**UPDATE OF LIST OF PLANNING APPLICATIONS TO BE DECIDED BY
PLANNING SUB-COMMITTEE (HUDDERSFIELD AREA)**

9 MARCH 2017

Planning Application 2016/92812

Victoria Works, Fisher Green, Honley, Holmfirth, HD9 6DP

Drainage Layout

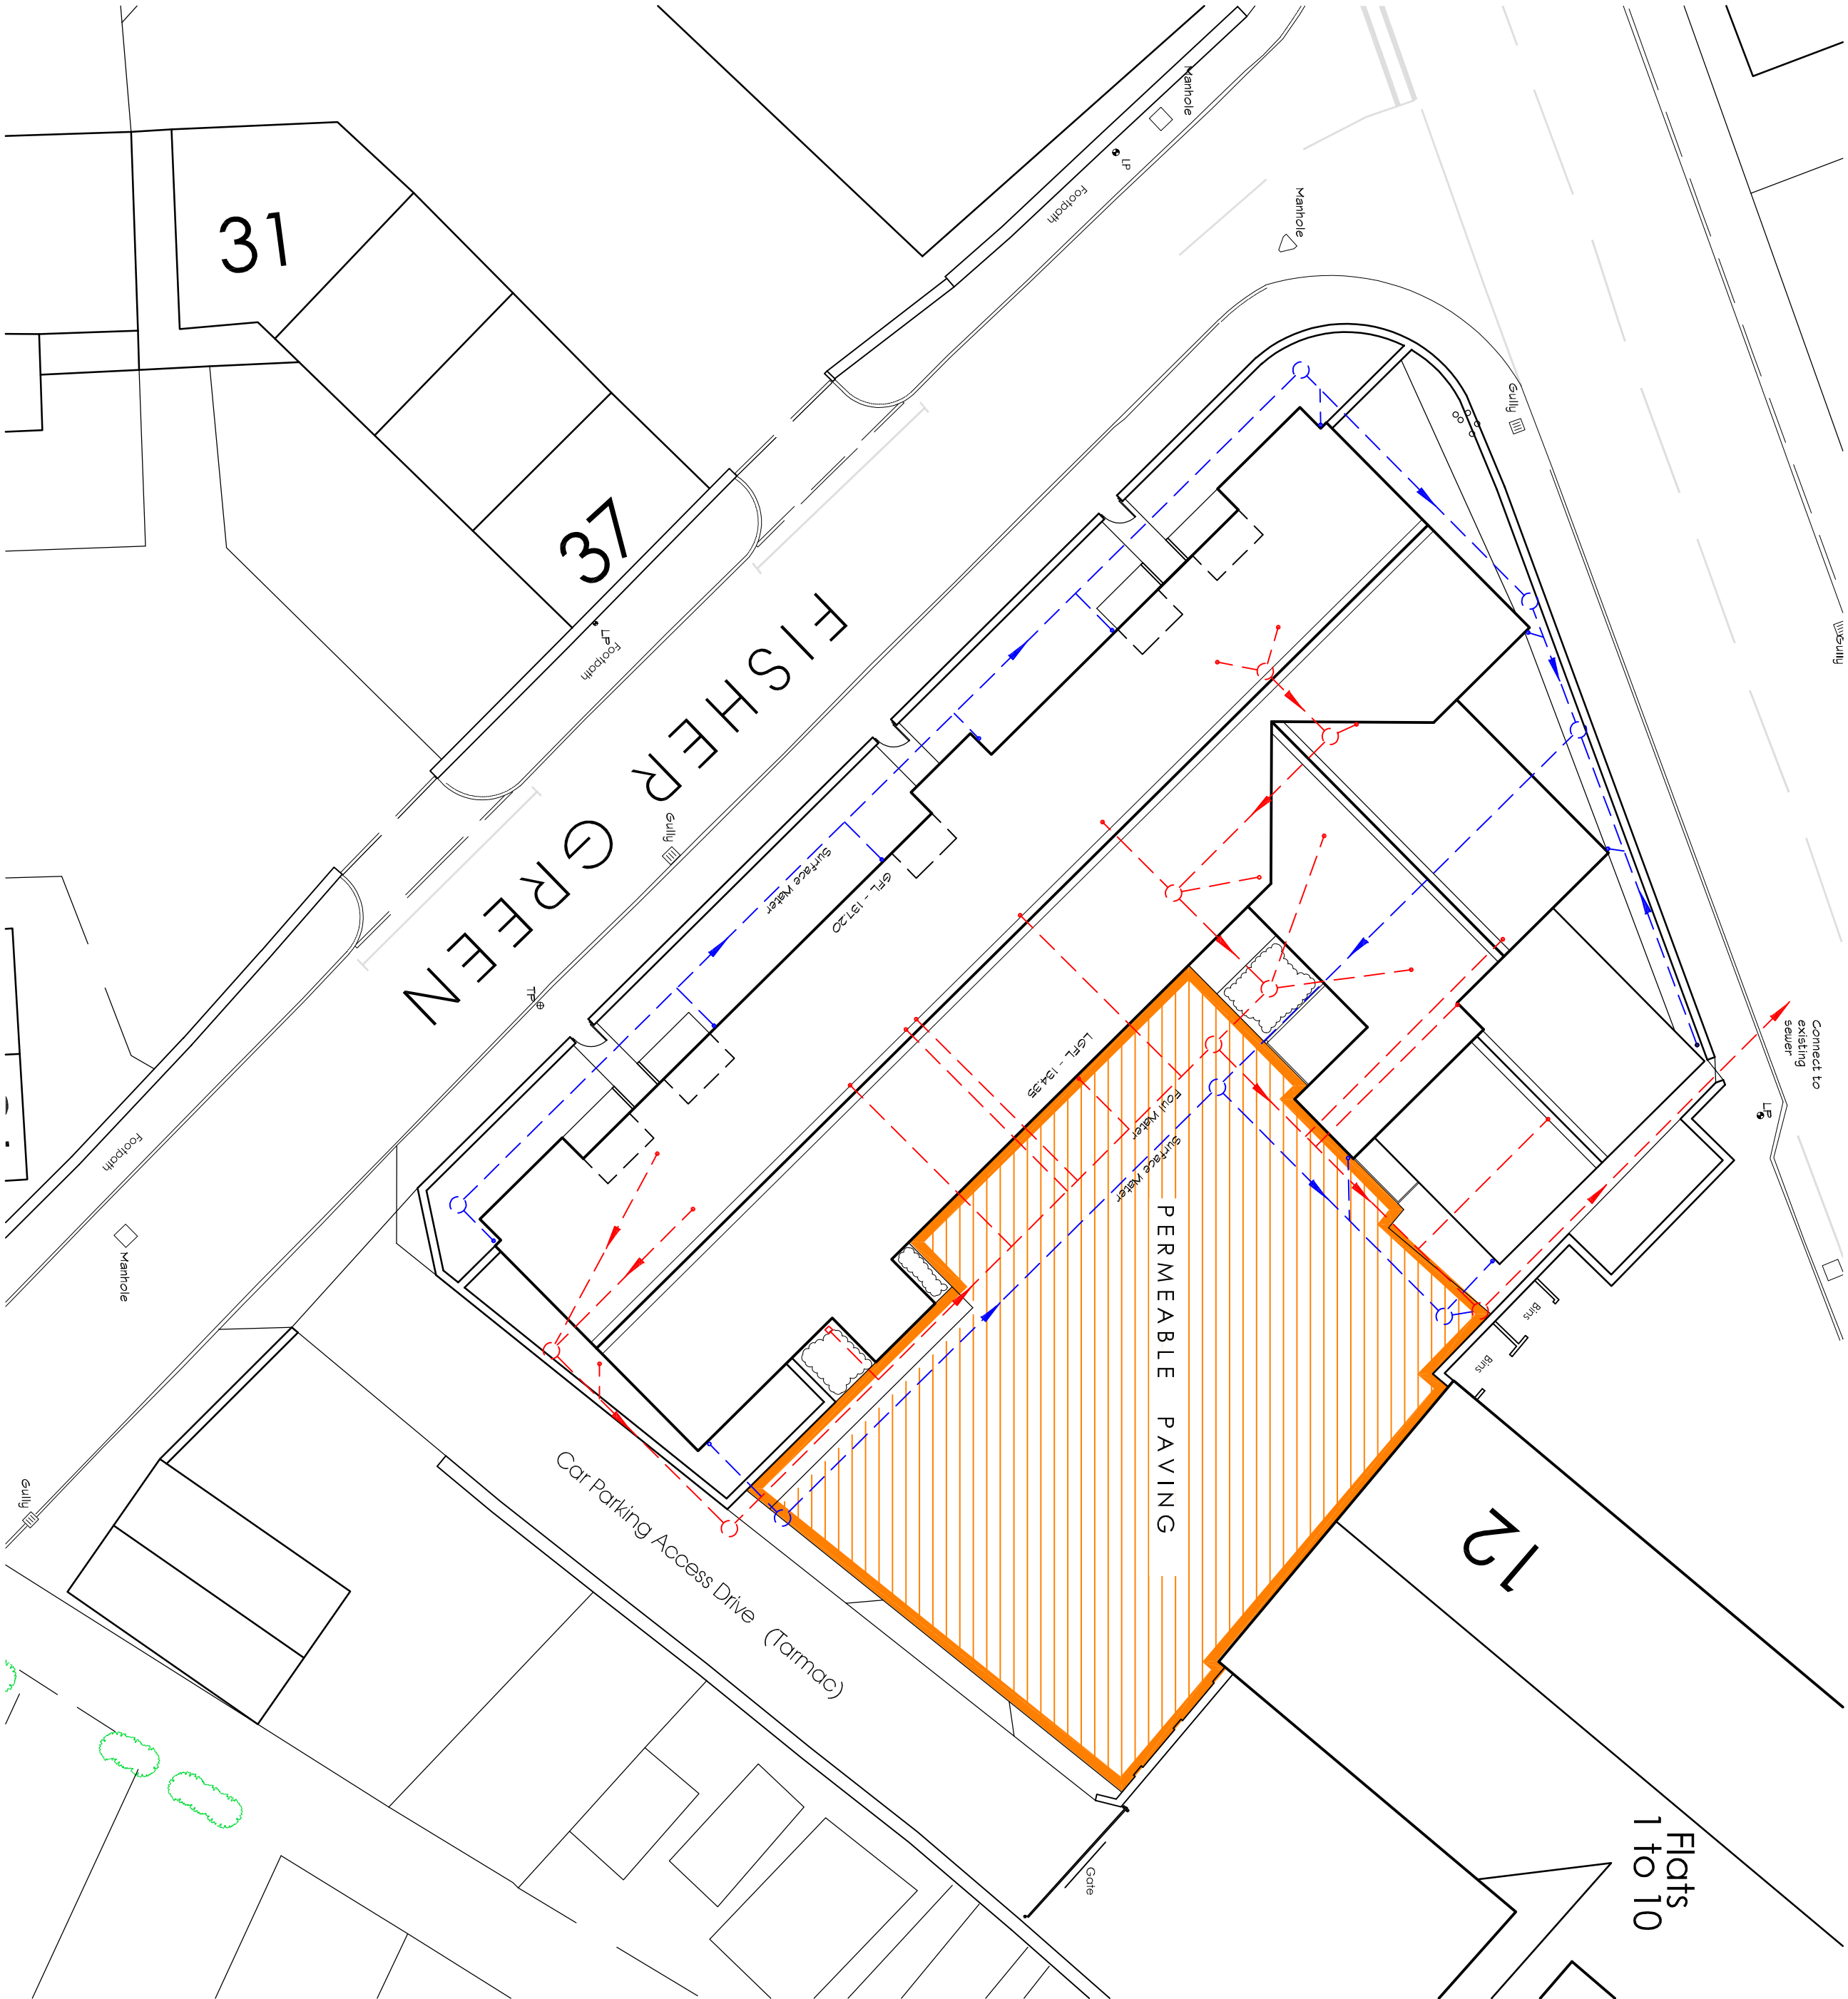
Formal comments are awaited from the Strategic Drainage Officer on the revised drainage proposals. In the absence of these, appropriately worded conditions no. 10 as set out in the agenda would address this issue, should Members be minded to accept the officer recommendation.
